**Environment
Agency**

Our ref: NE/2011/111405/01-L01
Your ref: N6/2010/3120/DC3
Date: 29 March 2011

Splashlands, Stanborough Road, Welwyn Garden City.

Redevelopment of site to provide a wet play area, adventure play areas, an educational play area, high ropes attraction, changing huts, education room, cafe and toilet facilities.

VIEWING PLATFORM PLAN
SCALE - 1:50

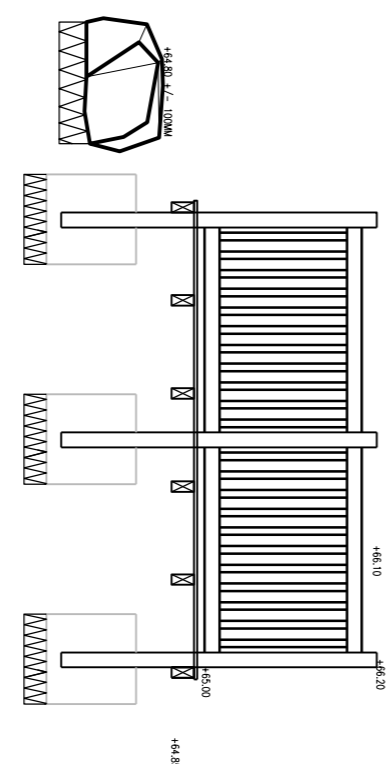
1. Provide sufficient information to demonstrate that the flood plain compensation scheme will ensure that there is no increase in flood risk as a result of this development.
2. Demonstrate that Sustainable Drainage Systems have been maximised for surface water attenuation.
3. No information has been provided about the timber viewing decks and other riverside features.

All works within 8 metres of the River Lee require Flood Defence Consent irrespective of planning permission granted. To ensure that the riverside features

are acceptable we will need to see further detail which demonstrates that there is no adverse impact upon river flows or biodiversity. Please contact Sarah Smith on 017007 632629 to discuss this further.

GENERAL SITE AREA DRAINAGE LAYOUT PLAN

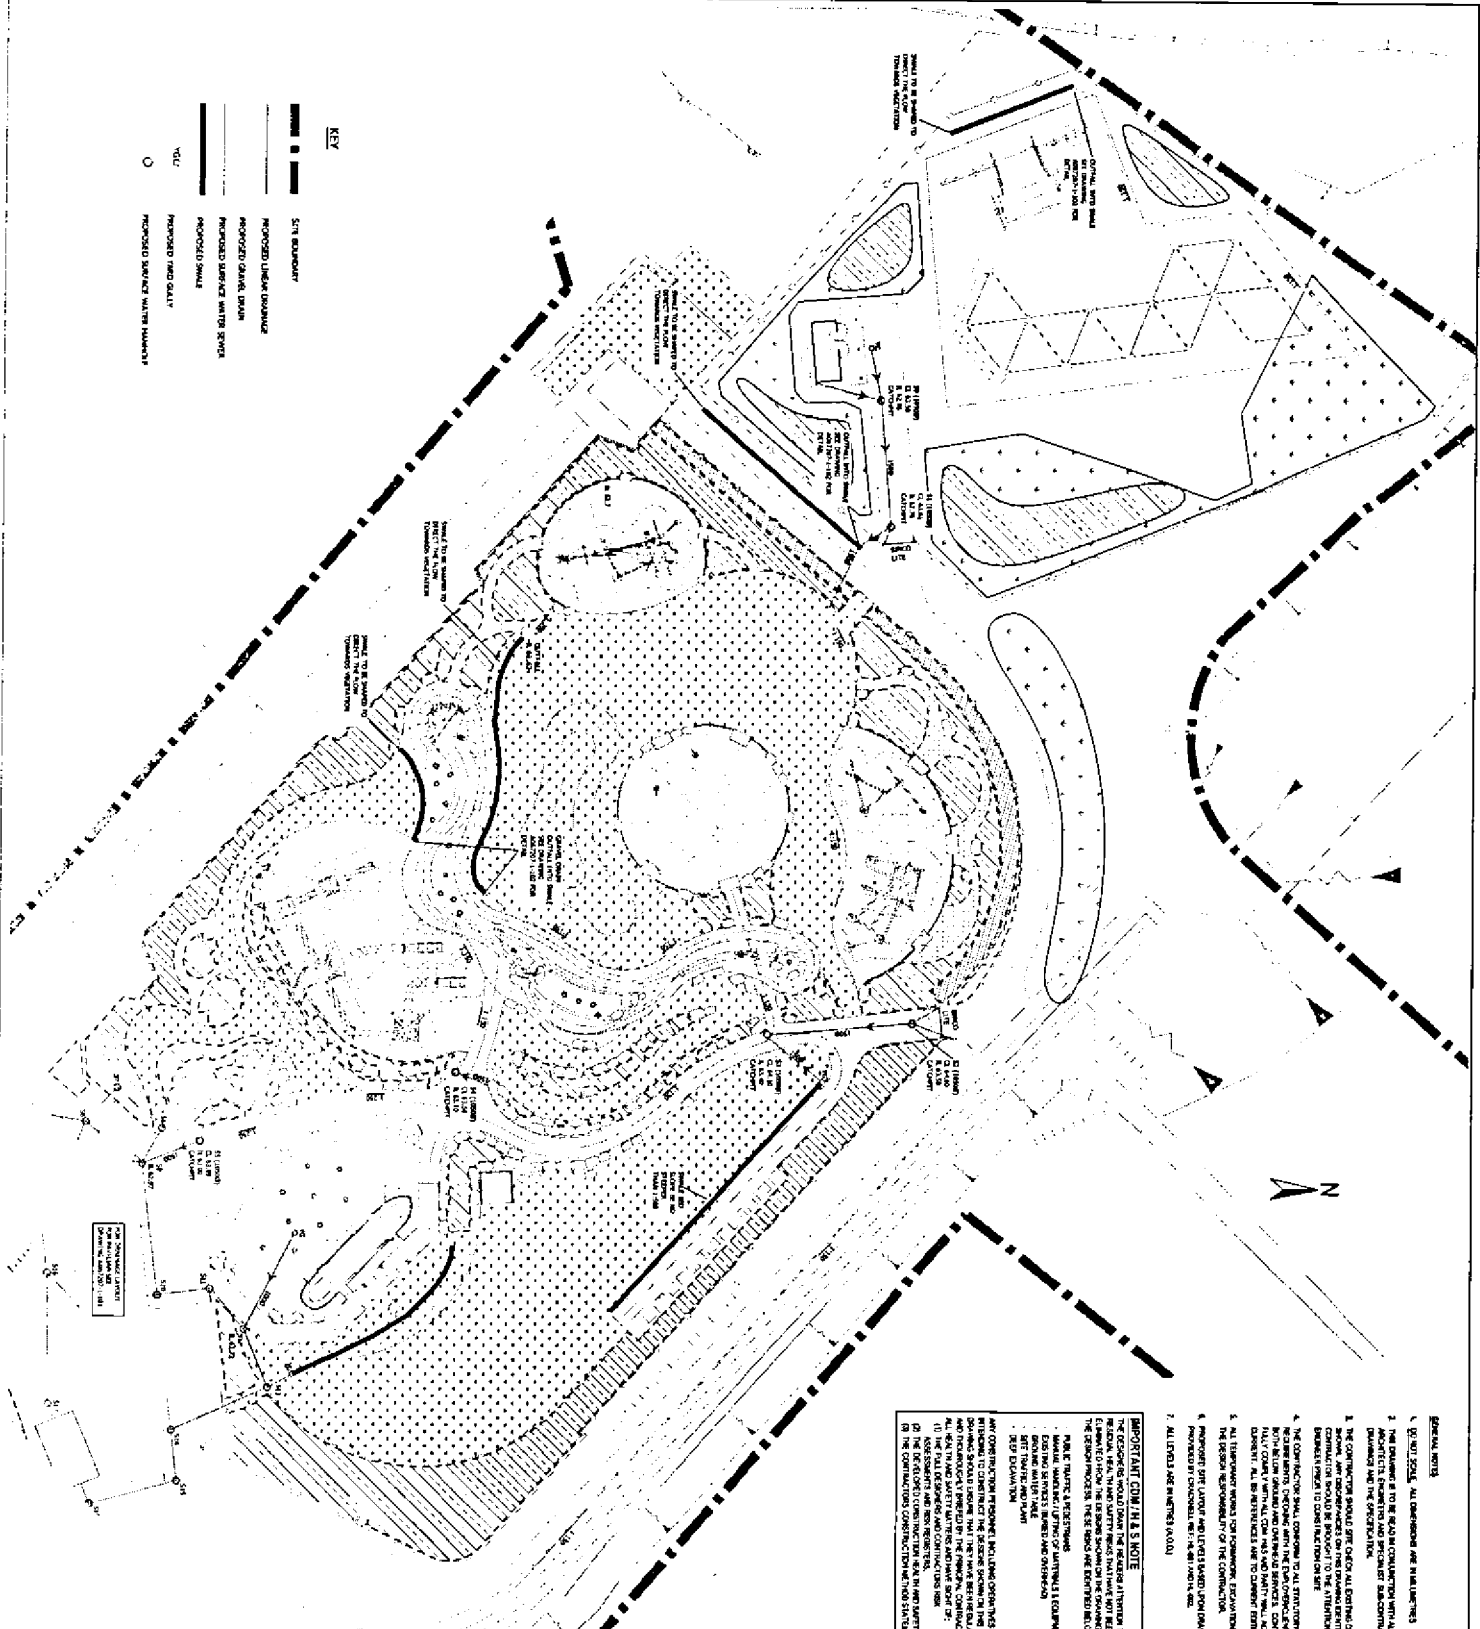
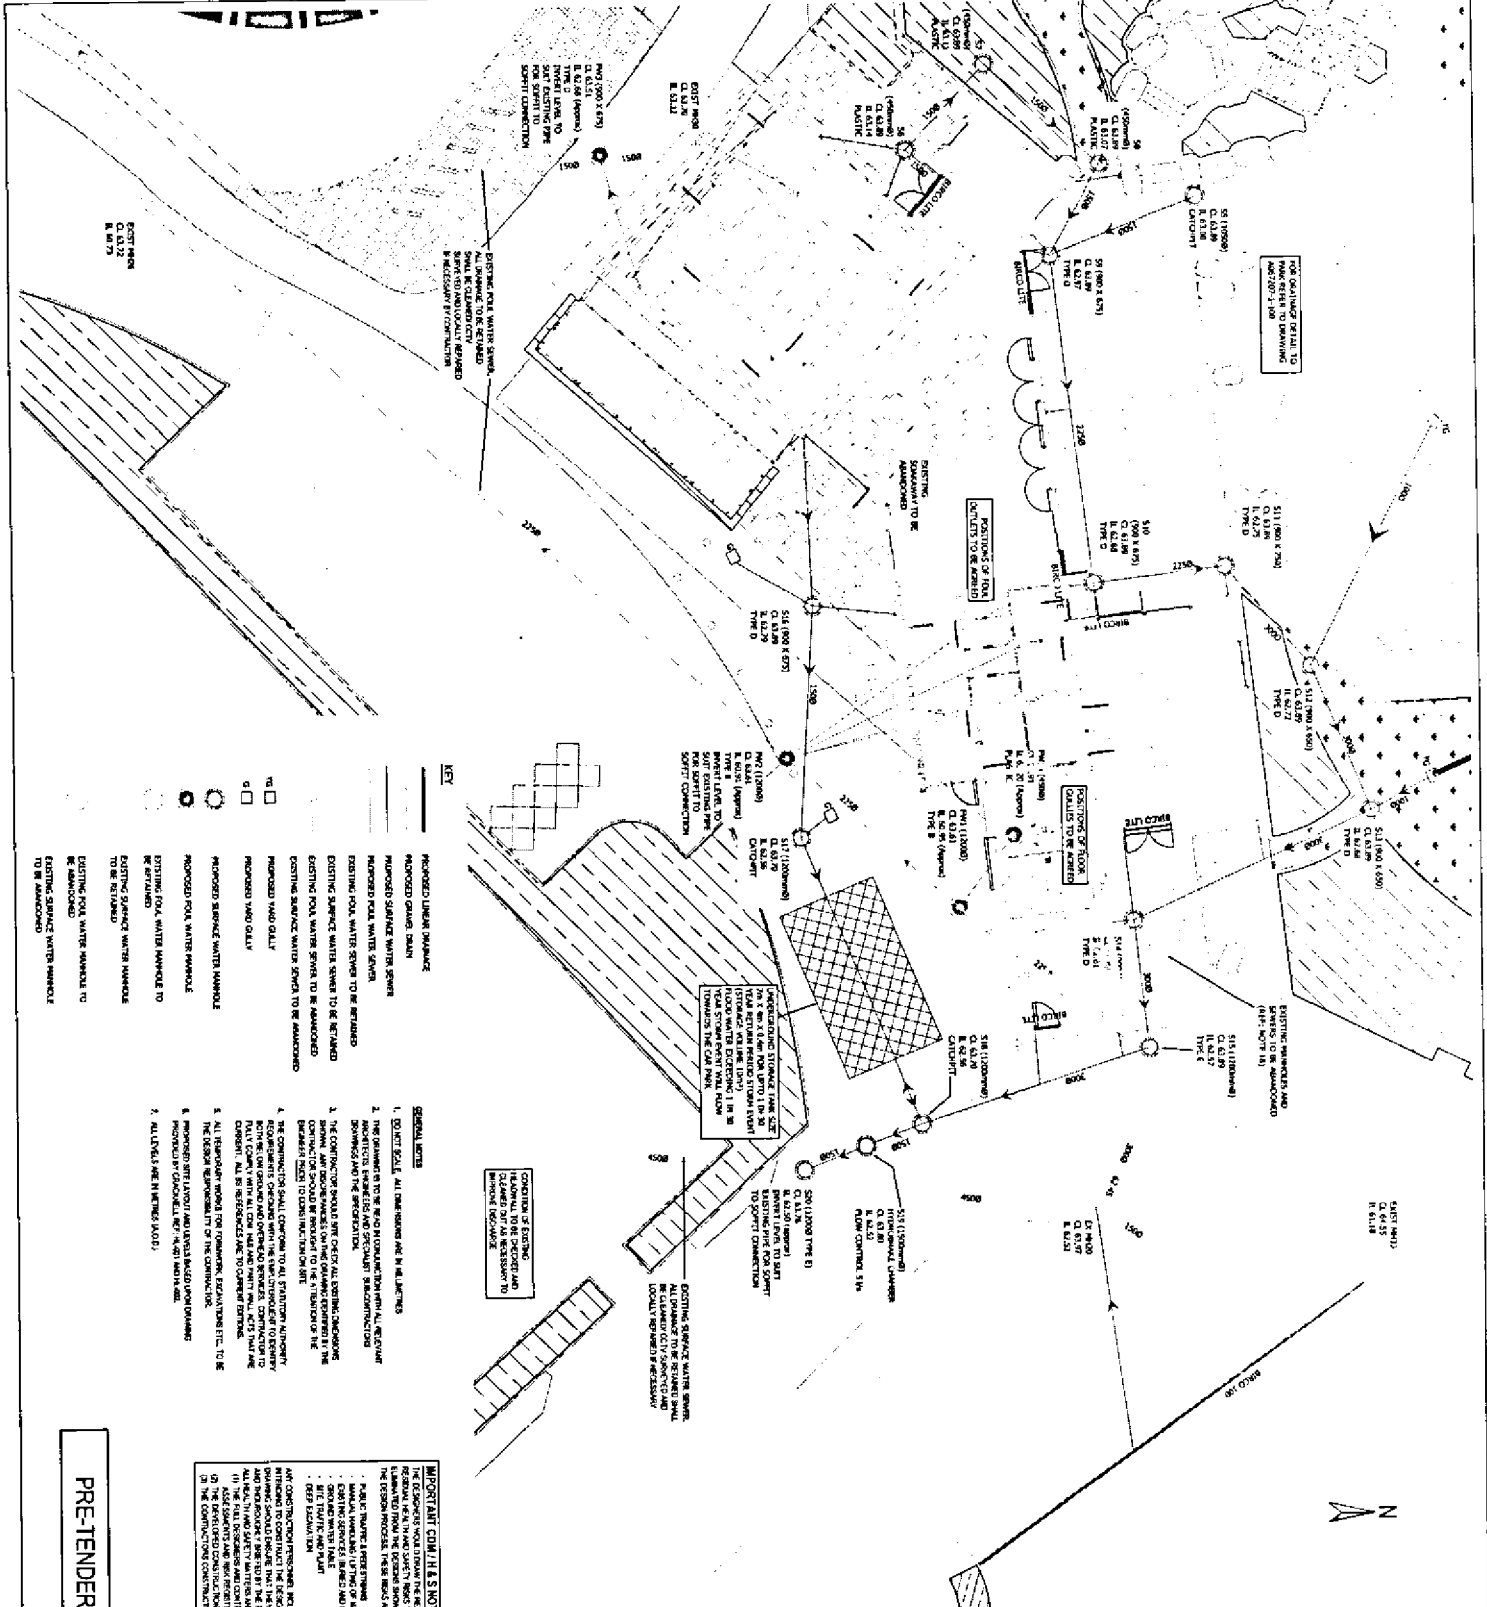
However, the FRA goes on to state that the required attenuation storage will be provided in oversized pipes underground storage tanks. No explanation is given for this decision. The applicant has not provided any justification as to why a more sustainable option has not been chosen.

For a site such as this which already features ponds, marshes and open green areas there appears ample scope to incorporate Sustainable Drainage Systems into the proposal. The surface water drainage scheme must be informed by the attached SuDS hierarchy and the most sustainable options must be incorporated into the site design. The current proposed use of oversized pipes and tanks is unacceptable.

PROPOSED EARTHWORKS & FLOOD COMPENSATORY PLAN
 SCALE 1:200

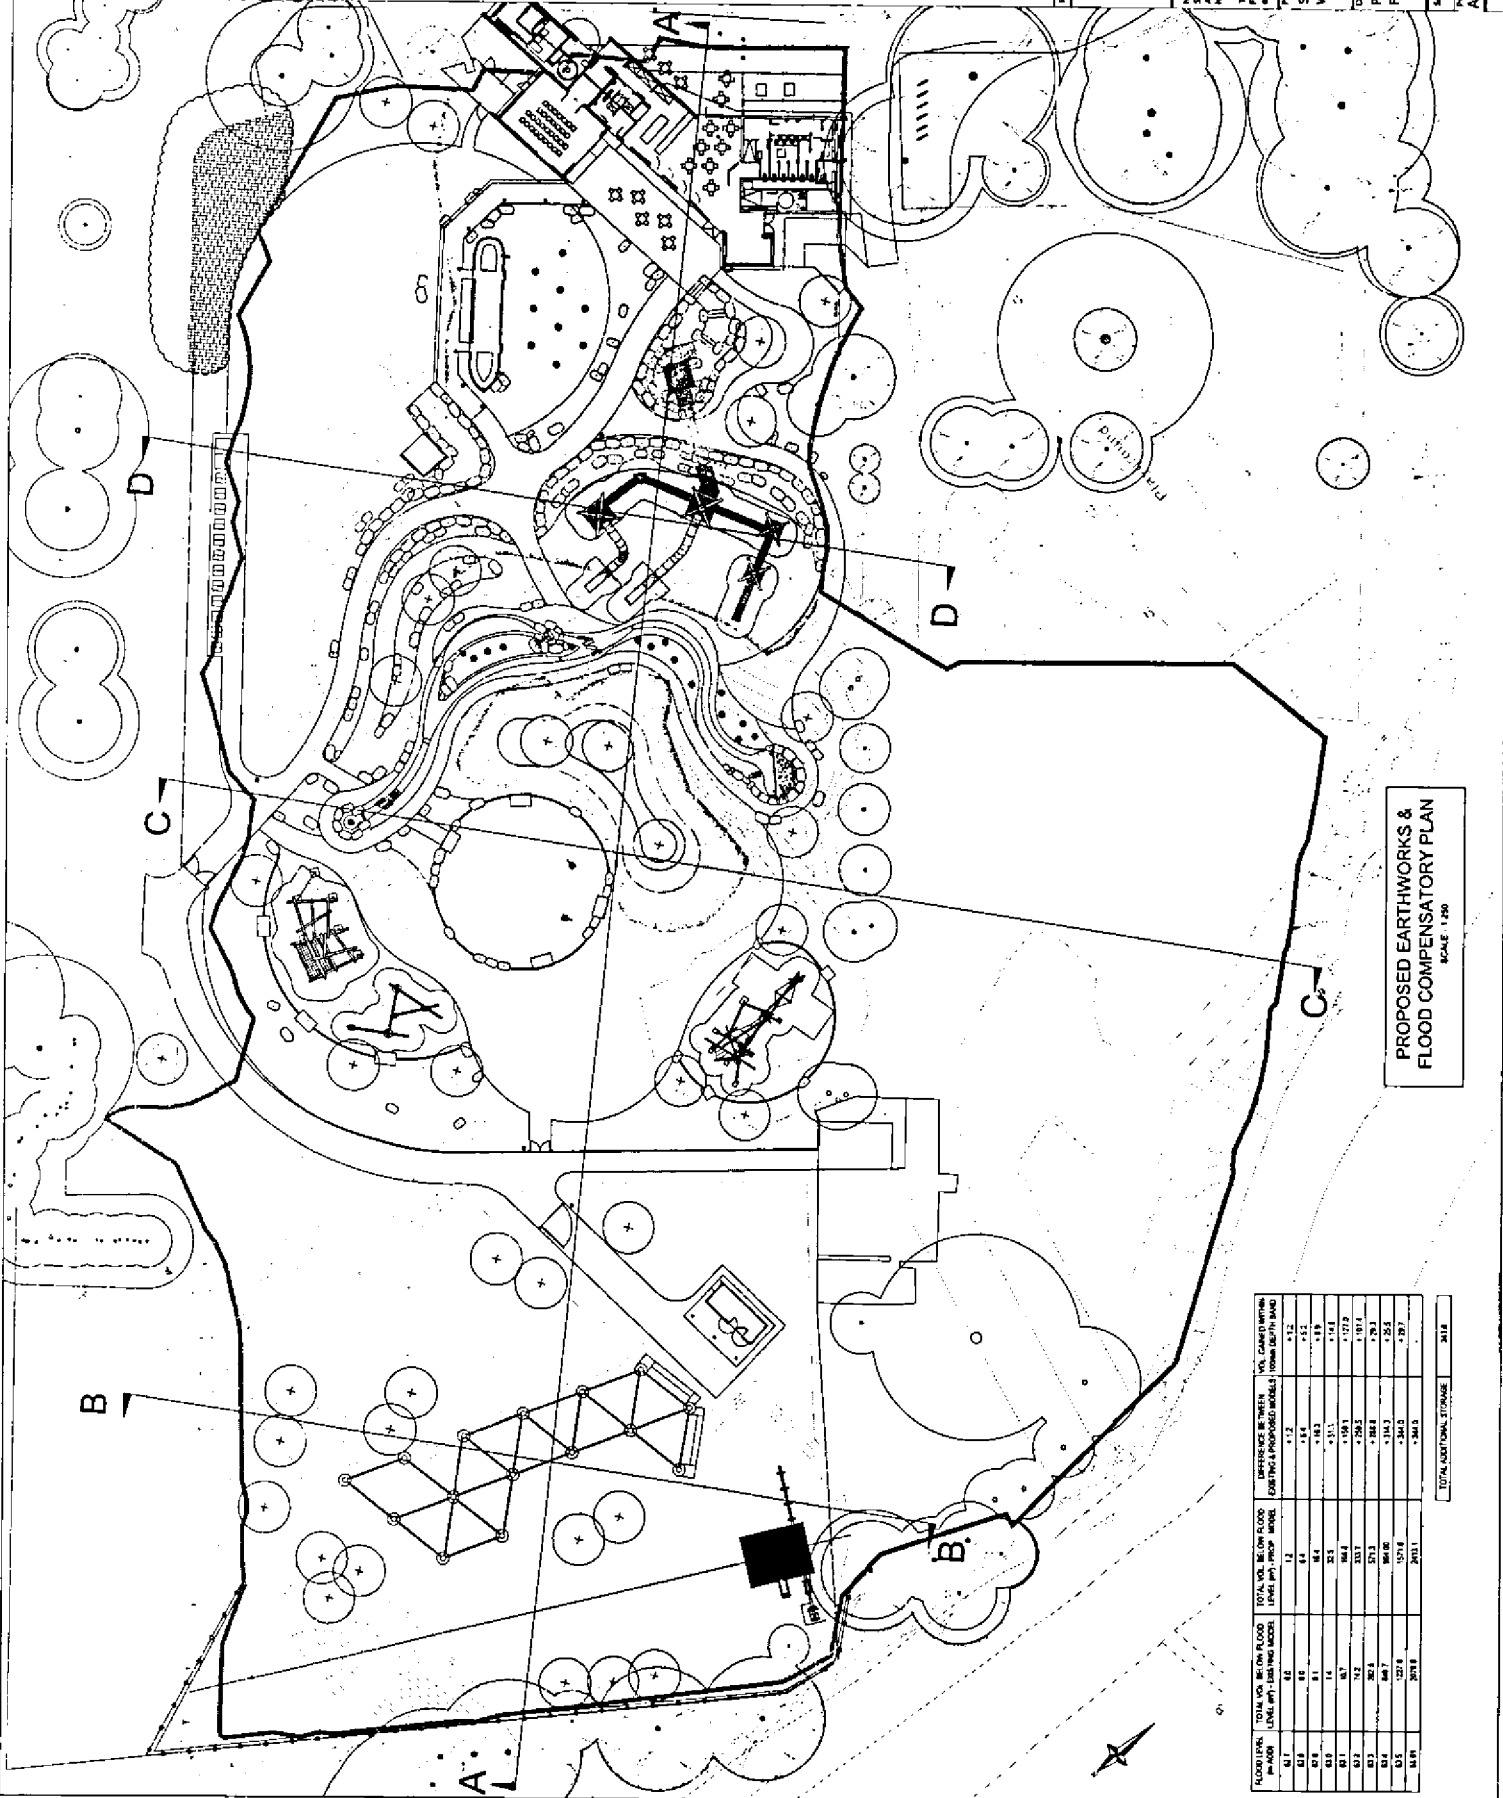
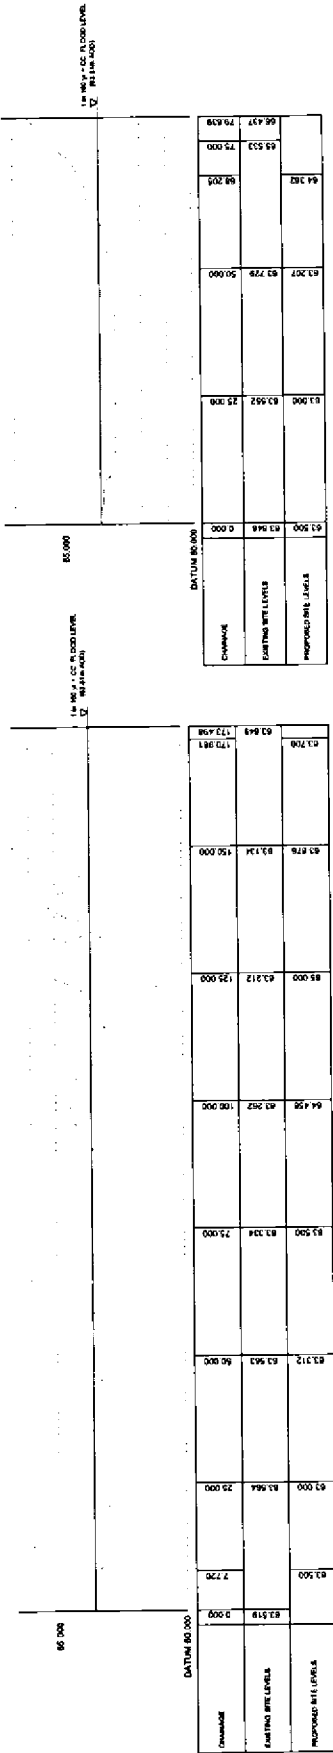
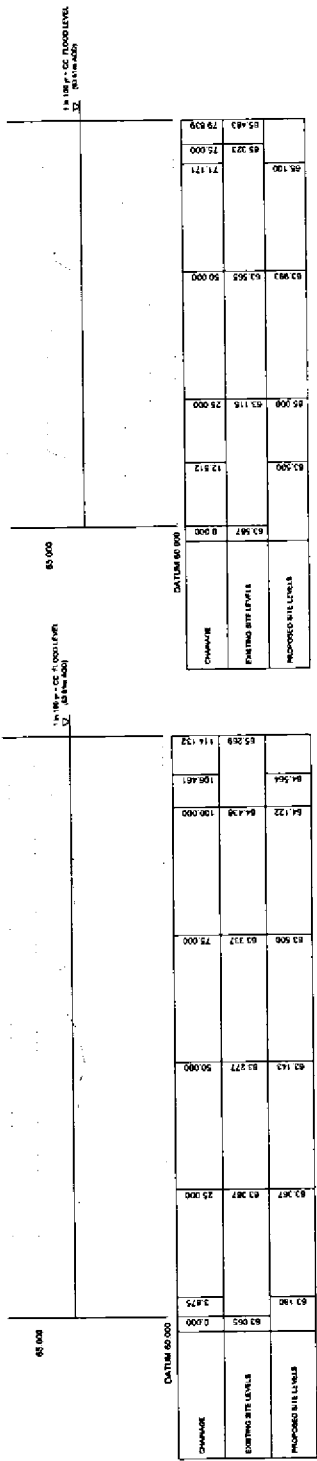
The FRA states that level for level compensation will be provided. This has not been supported by the required evidence and the FRA does not detail how this

will be achieved. Our basic requirements for compensatory flood plain storage are:

- A volume of flood plain equal to that lost to the proposed development must be created.
- The equal volume must apply at all levels between the lowest point on the site and the design flood level. Normally this is calculated by comparing volumes taken by the development and the volume offered by the compensatory storage for a number of horizontal slices through the range defined above (see the example of compensatory storage on the last page for a depiction of this).

- The thickness of a slice should be typically 0.2 metres. In the case of large flat sites or very steep sites this may be varied to 0.1 or even 0.05 metres. The slice thickness should be set to provide between ten and fifteen slices for such unusual sites.

- Compensatory storage must be provided equal to or exceeding the development for each of these slices to ensure there will be no net loss of flood storage.

- Excavation of the compensation scheme must be complete before infilling commences to ensure that flood plain capacity is maintained during construction of the development.
